Proposed Dargues Reef Mine – Modification 3 Comments on Response by Proponent

Eurobodalla Shire Council (ESC) and Palerang Council (PC) briefed Dr Peter Beck of GHD Pty Ltd (GHD) to provide comment on the responses prepared by the proponent to GHD's report on the proposed Modification 3 to Mining Operations at the Dargues Reef Mine Project (the Project Site), currently in the process of being developed. GHD had prepared a report with comments on the proposed modification as follows:

- GHD, 2015, "Eurobodalla and Palerang Shire Council - Proposed Dargues Reef Mine, Review of Proposed Modification 3 Change to Mining Operations", Ref G:\31\2904000\WP\245897.docx, dated 26 August 2015

- RW Corkery, 2015, "*Response to Submissions Dargues Gold Mine - Modification 3*", November 2015, Ref No. 752/42

DARGUES GOLD PROJECT  
SEEPAGE ANALYSIS  
EXPECTED OPERATIONAL CONDITION

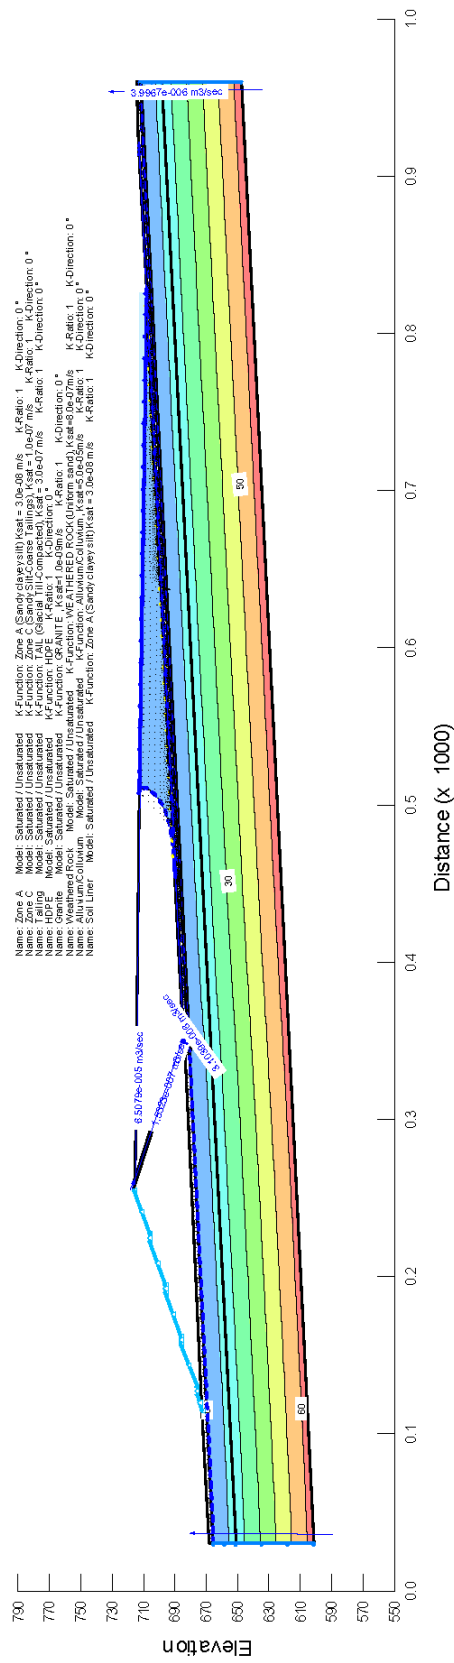
The proponents calculation seems flawed. There are 86400 seconds in a day. Therefore the leaching rate would be 16,160 L/day not 269 L/day. It appears that the proponent used a leaching rate of 0.187 L/min not 0.187 L/sec. This would result in a significant overestimation of the dilution factors.

Using the correct conversion factor for L/sec to L/day the dilution factor would be 2660 not 159 851.

Therefore after taking dilution into consideration the Chromium Concentration would be 0.25 mg/L under minimum flow conditions, which exceeds the drinking water criteria of 0.05 mg/L.

Therefore our original point would remain valid and highlights that the proponents risk assessment had not adequately characterised the potential impact from the proposed TSF and associated leachate discharge.

GHD disagrees with the Knight Piésold seepage calculation as they assumed ideal conditions and performance long term. As the liner proposed is not commensurate with even the minimum liner for a landfill the application of liner installation and degradation rates applied to landfill liners was considered reasonable and would provide a more realistic estimate of the long term leaching rate.
